NOISE IMPACT ASSESSMENT

Prepared For : Clitheroe Football Club Limited

Site : The Loom Loft Stadium, Pendle Road, Clitheroe BB7 1LZ

Report No. : 11506

Client: Clitheroe Football Club Ltd.		
Project: Proposed New Clubhouse & Community Hub Shawbridge Pendle Road Clitheroe		
Dwg title: Proposed Ground Floor Plan		
Scale: A4: 1:100	Date: 30.07.25	Drawn by: PD
Drawing no. 1720 - 04		Rev. B

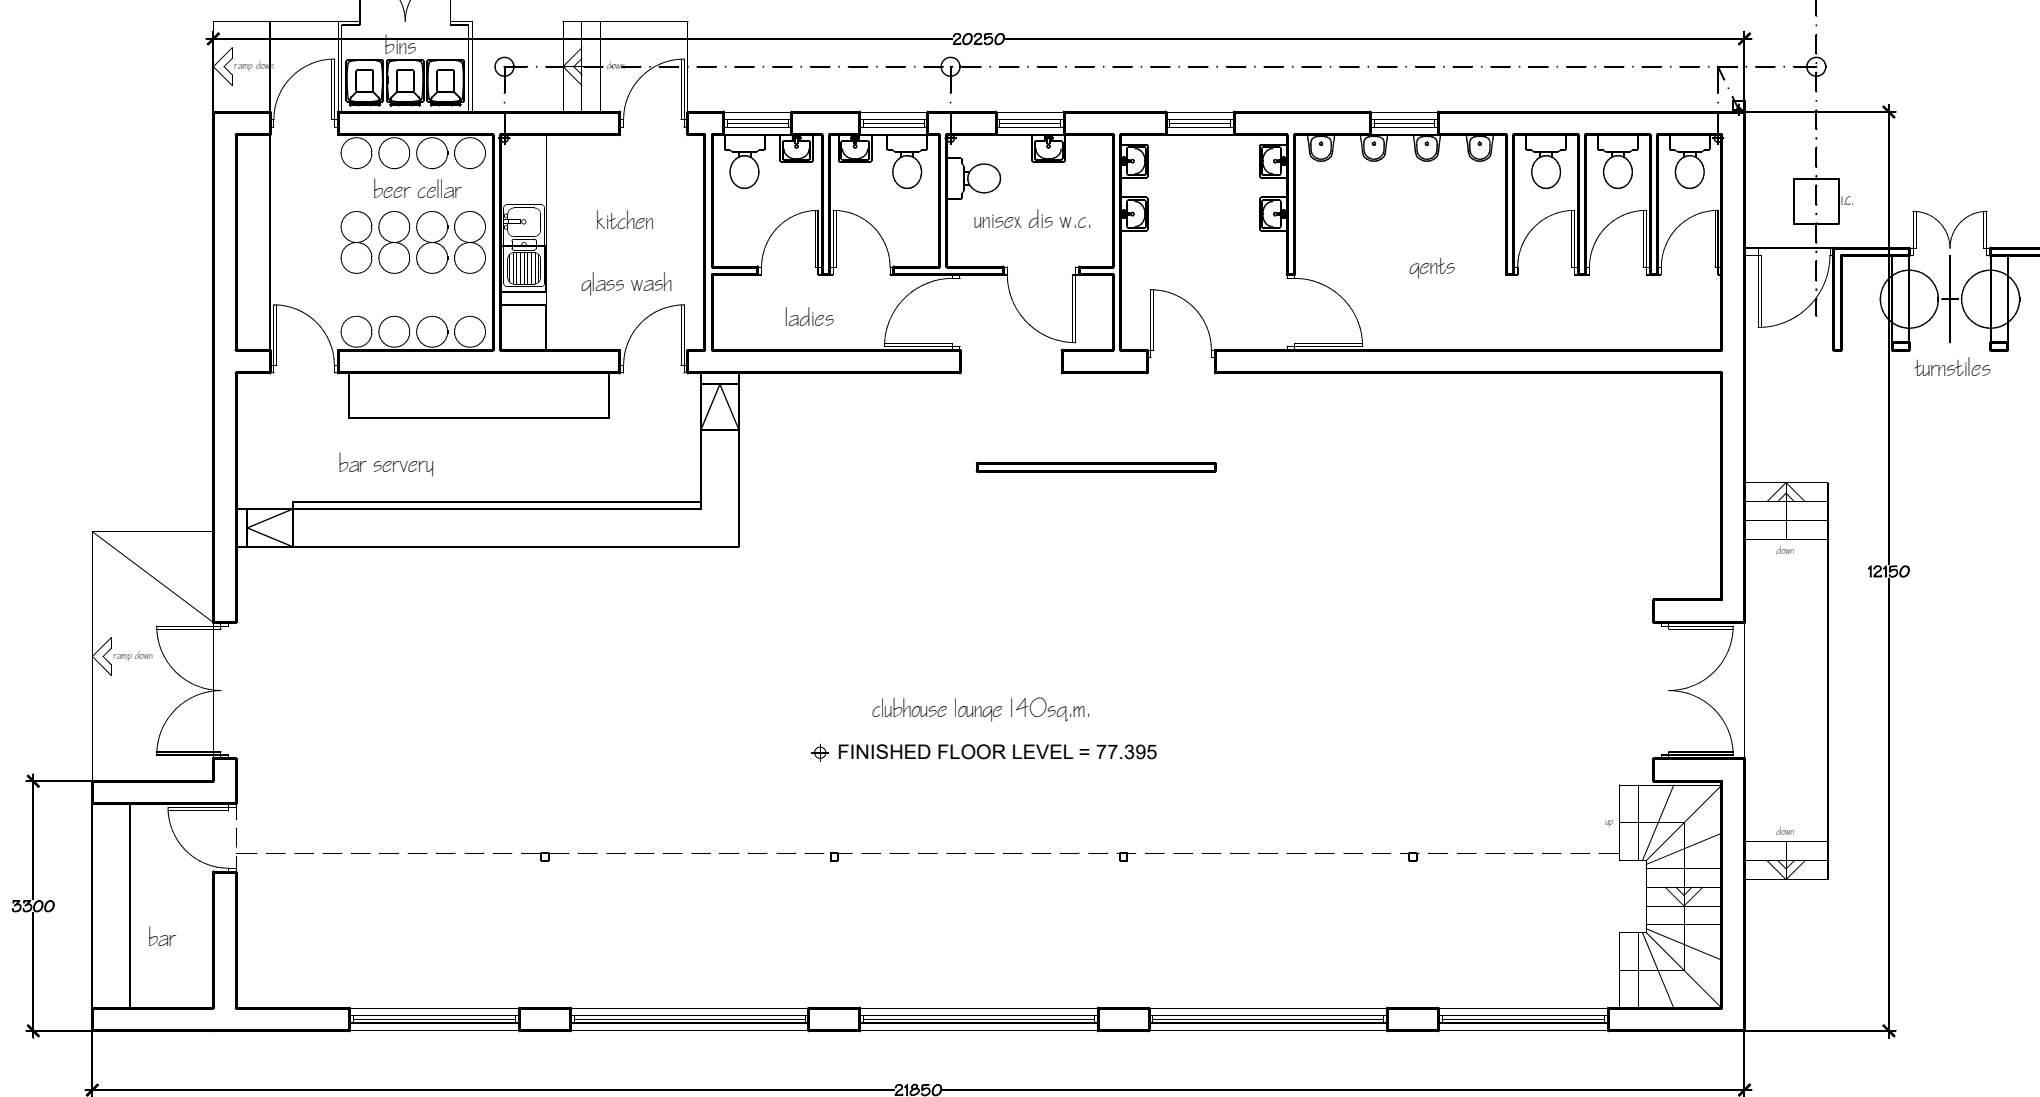
There is currently no lobbied door system. A lobbied door system should be installed, as per the glazing performance⁶ of 33 dB $R_w + C_{tr}$. The drawings will need to be updated to reflect this.

- A lobbied door system should be installed to both side elevations to ensure that any access point has at least one door closed at any one time.
- The existing air conditioning systems will be repurposed so that windows and doors need not be opened for ventilation.
- The sound system should have the following specifications:
 - Loudspeakers should be smaller and frequently (i.e. more speakers rather than fewer) distributed around the space.
 - All loudspeakers should be isolated from the structure using anti-vibration mounts

- The solidcore doorset to the external bar should have the same Sound Reduction Index as above.
- The double doors on both side elevations should have lobby access (also with a Sound Reduction Index of 33 dB $R_w + C_{tr}$) to prevent sound leakage when the doors are opened for ingress and egress.

| Dwg title:<br>Proposed Cross Section                                                            |                   |                 |

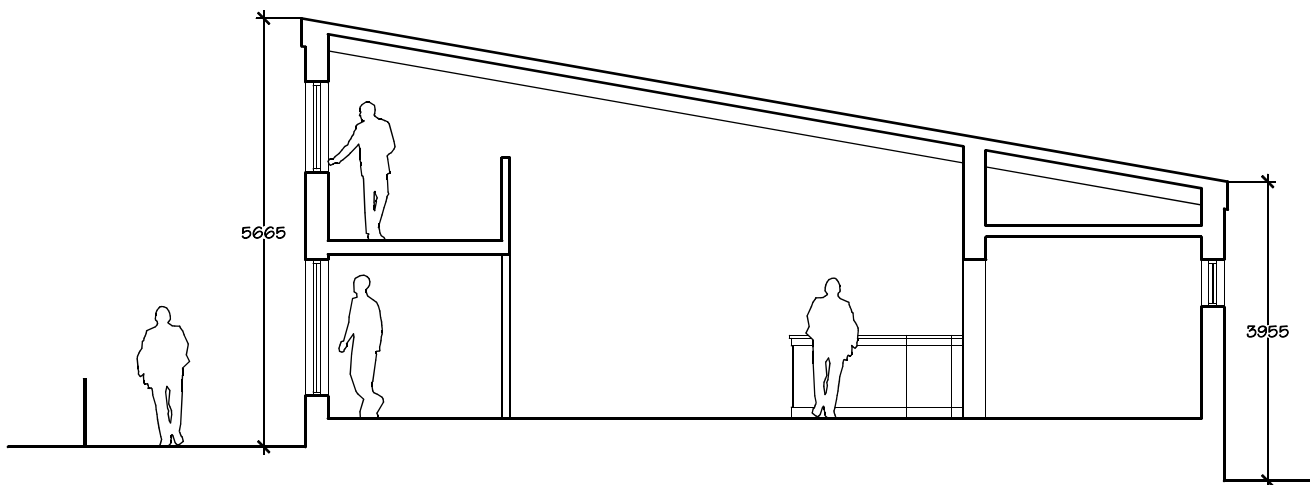
The roof insulation performance appears low 40–45 dB for the roof is relatively weak compared to walls. In music venues, the roof is often the primary pathway for breakout noise, especially low frequency.

Interesting, the 'weaker' façade for noise breakout is the rear, even though it is 14m further away. This is because a lot of the total façade area is the roof, which is a poor sound insulation that a cavity blockwork wall.

The ceiling is to be upgraded to 2 x 15mm Soundbloc on resilient bars. There should only be penetrations in the ceiling for cabling (or equivalent diameter) and then sealed with acoustic mastic.
